OUT20/9007

**New Berrima Brickworks Facility (SSD 10422) –
EIS Exhibition**

Simon Francis
Senior Project Officer
DPIE Water – Strategic Relations
9 September 2020

# LDA-04

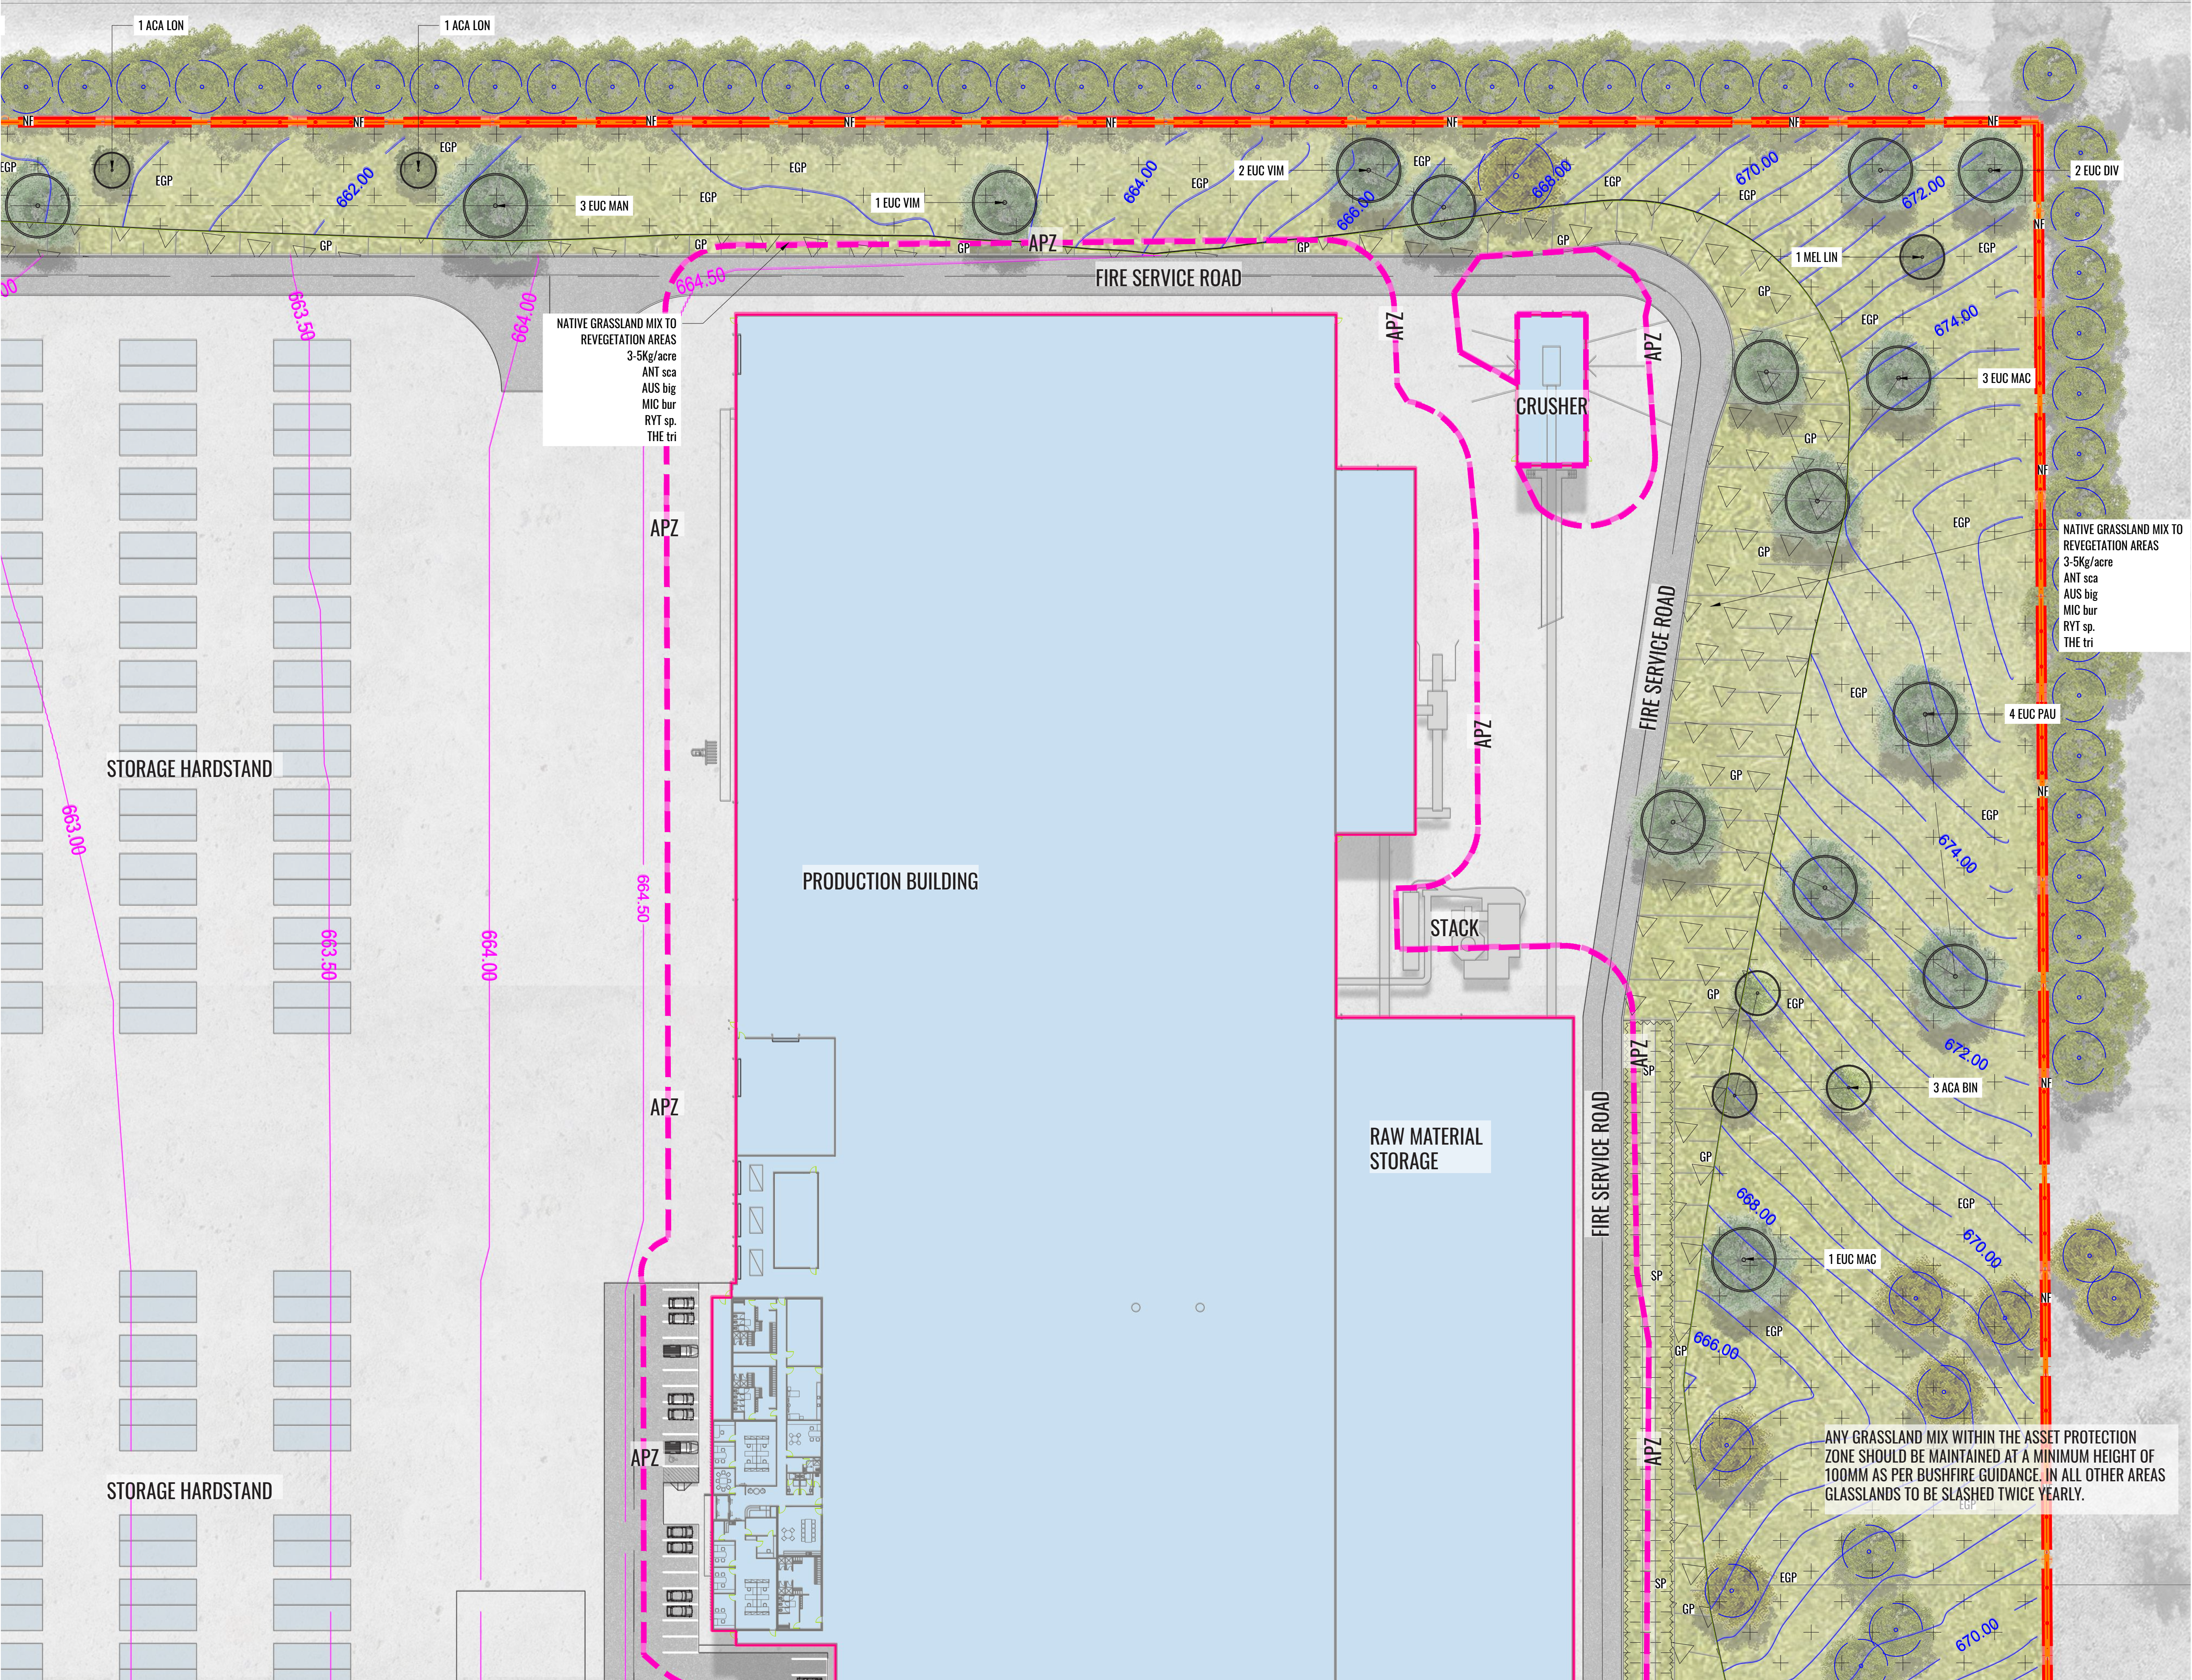
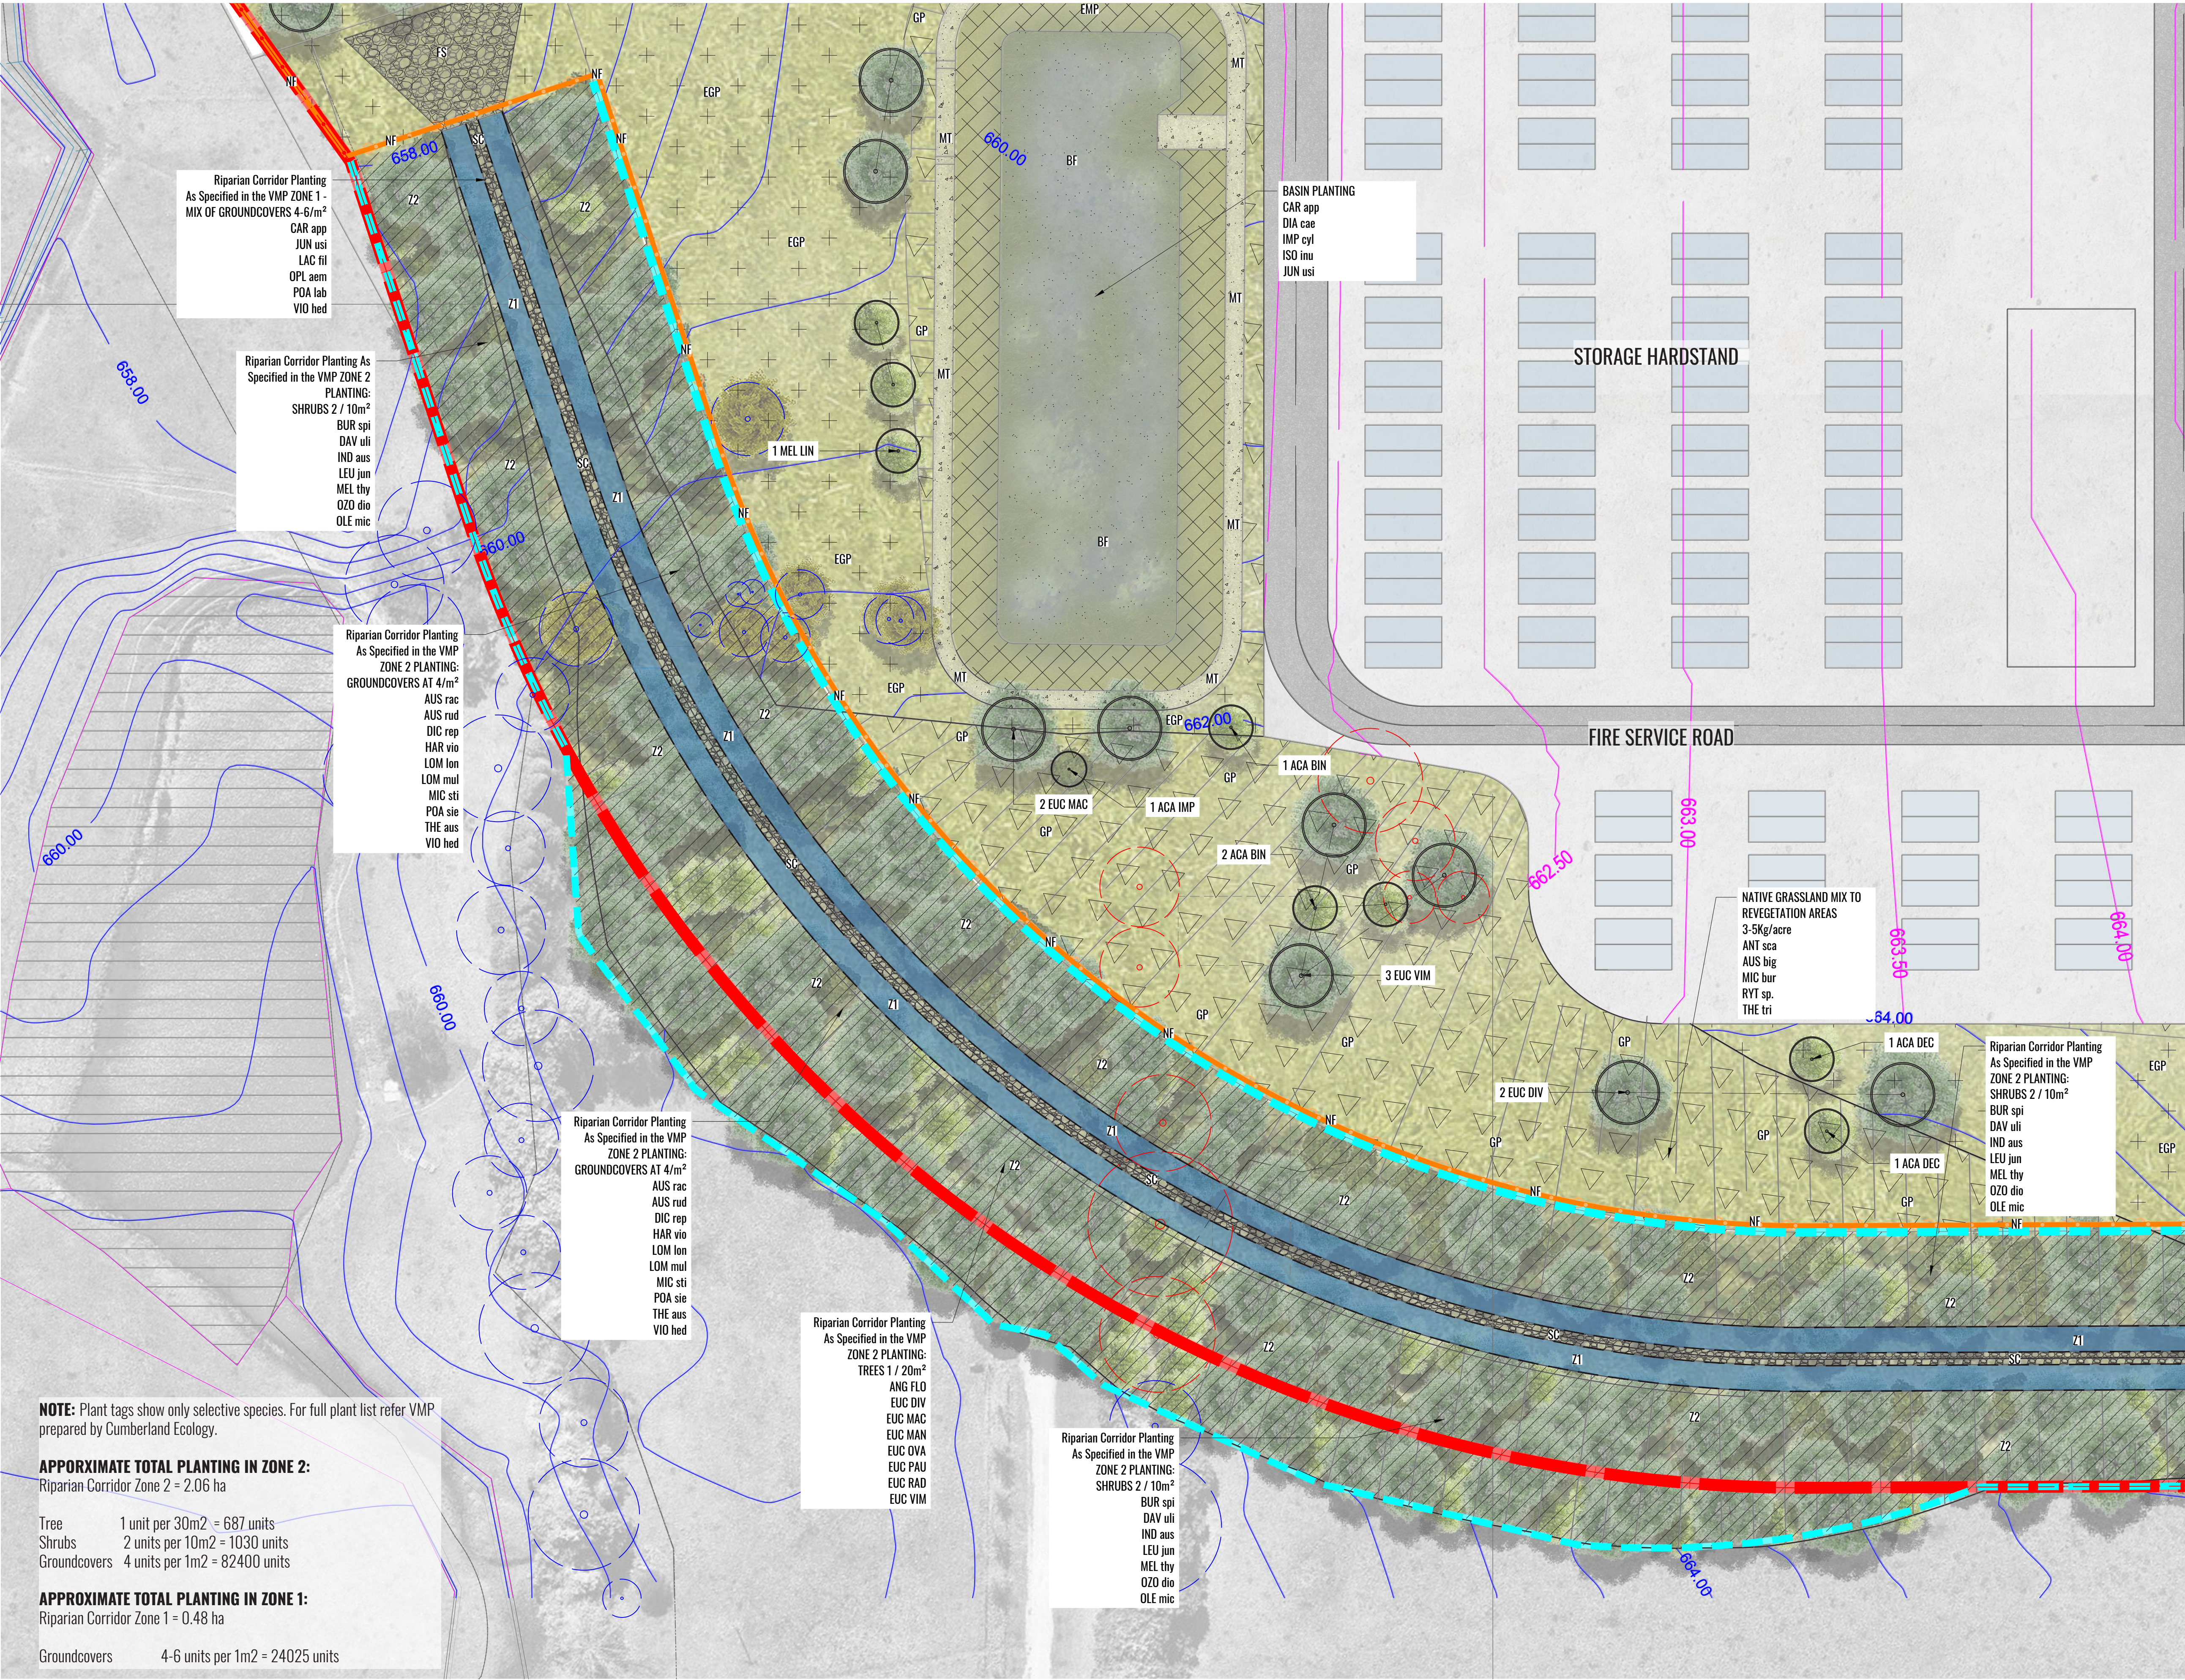
- A Surface Water Monitoring Plan (to assess, monitor and rehabilitate erosion and sedimentation impacts after high flow events).
 - It is noted that overland flow from the 2nd order realigned watercourse enters a flow spreading structure which may not mitigate all erosional impacts between the flow spreader and Stony Creek.
- The implementation of the Vegetation Management Plan (VMP).
 - It is noted that a VMP (Cumberland Ecology, May 2020) has been provided with the EIS detailing vegetation establishment and maintenance across the area of the realigned 2nd order watercourse. However, mitigation measures provided in the EIS do not detail the implementation of the VMP as a requirement.
